Our reference: DOC 12/46368, FIL10/14253
Contact: Brad Tanswell 02 6883 5330

I refer to the Project Application, Environmental Assessment (EA) and accompanying information provided for the proposed Cobbora Coal project (ref 10_0001) received by the Environment Protection Authority (EPA) on 5 October 2012.

BRAD TANSWELL
A/Head Pesticides, Operations and Planning
Environment Protection Authority NSW

Figure 3.1

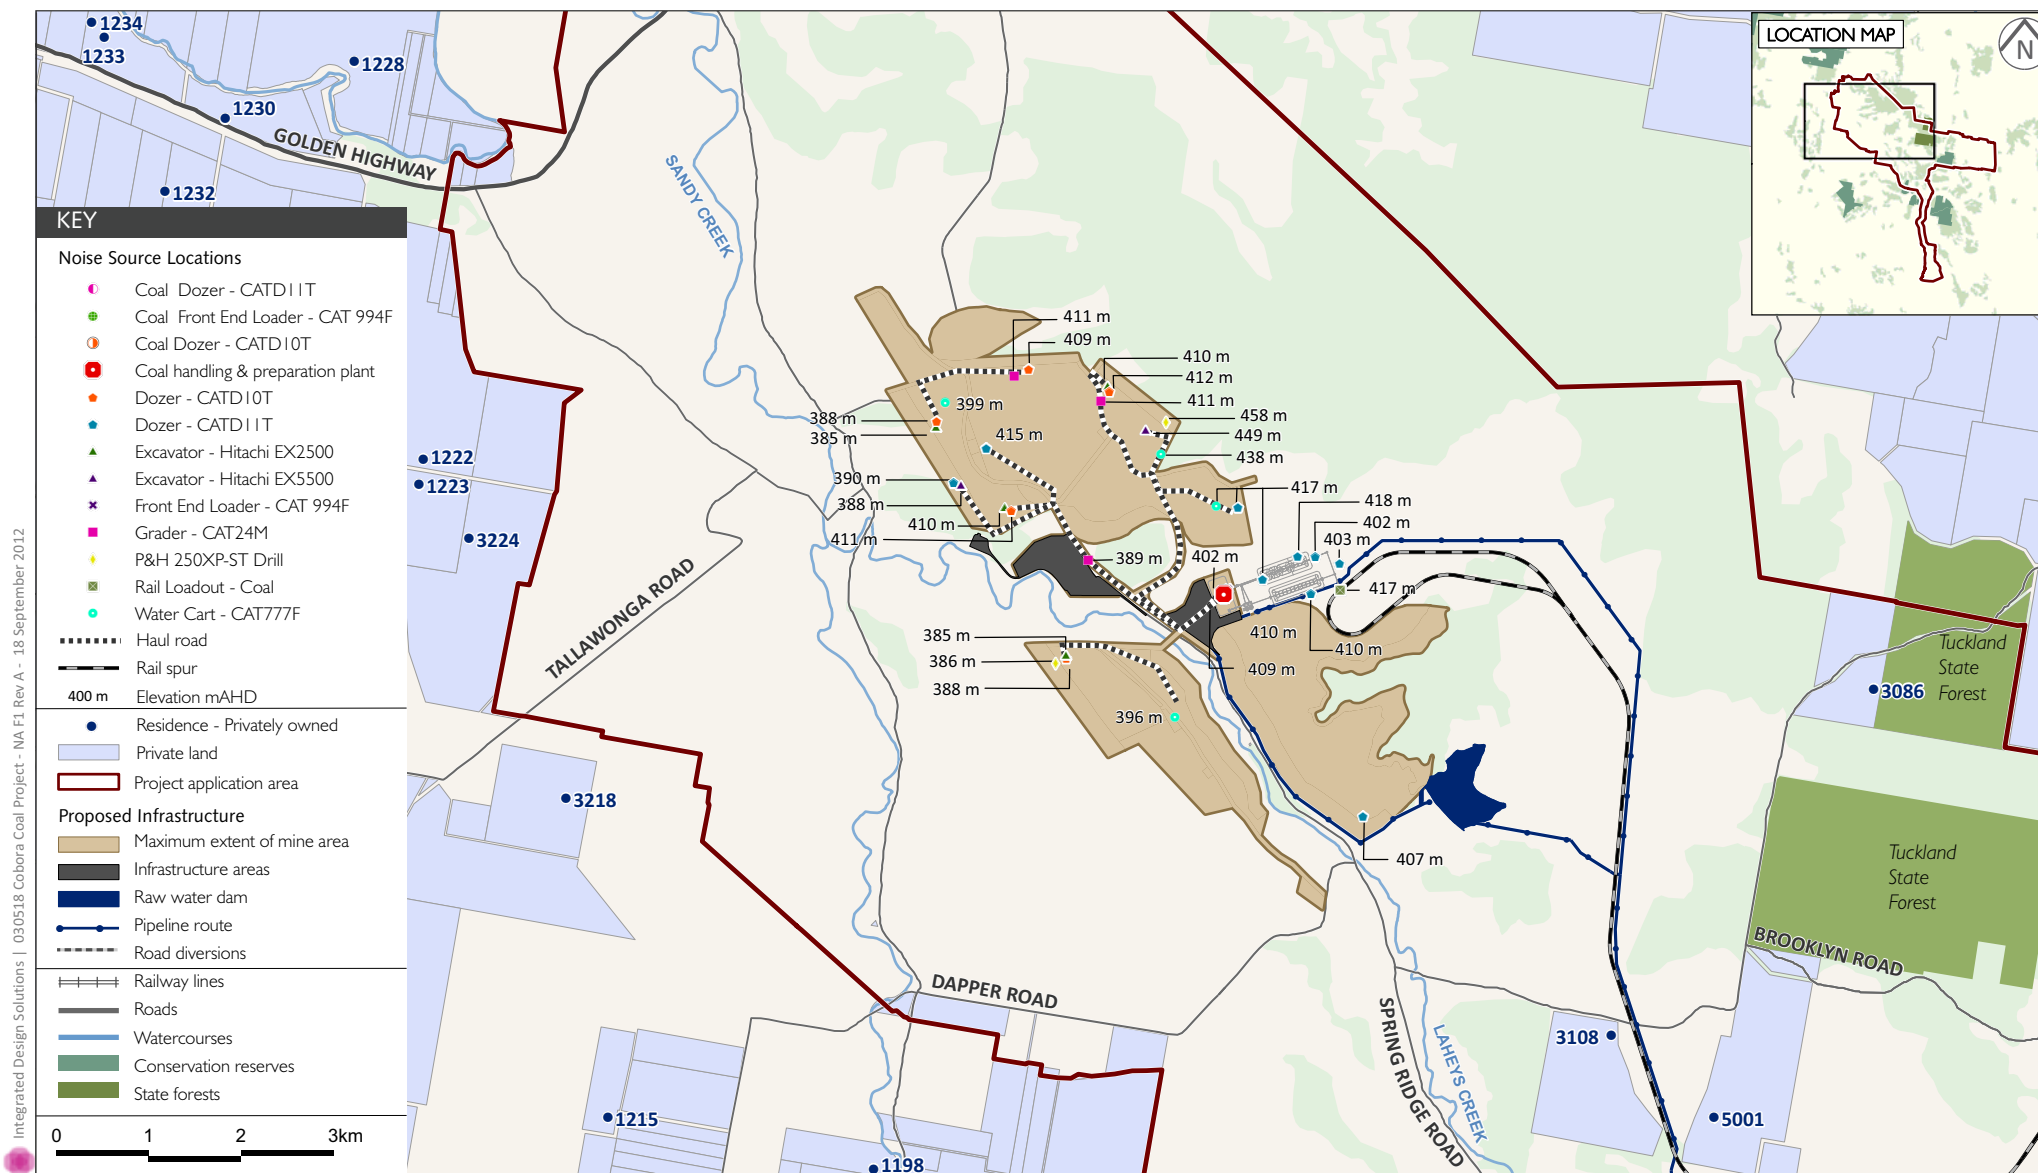
The EPA notes that the modelled elevations of some plant (particularly the Rail Loadout and the CHPP) vary between years. For example, the Rail Loadout is at 417m in Figure 3.2 (Year 2 Modelled Plant Locations) and is at 410m in Figure 3.3 (Year 8 Modelled Plant Locations). The CHPP is at 402m in Figure 3.3 (Year 8 Modelled Plant Locations) and is at 409m in Figure 3.4 (Year 16 Modelled Plant Locations) then at 410m in Figure 3.5 (Year 20 Modelled Plant Locations). The EPA requires clarification of whether fixed plant such as a Rail Loadout and CHPP would actually increase or decrease in elevation throughout the life of the mine and if not then the model should be amended accordingly and new predicted levels provided.
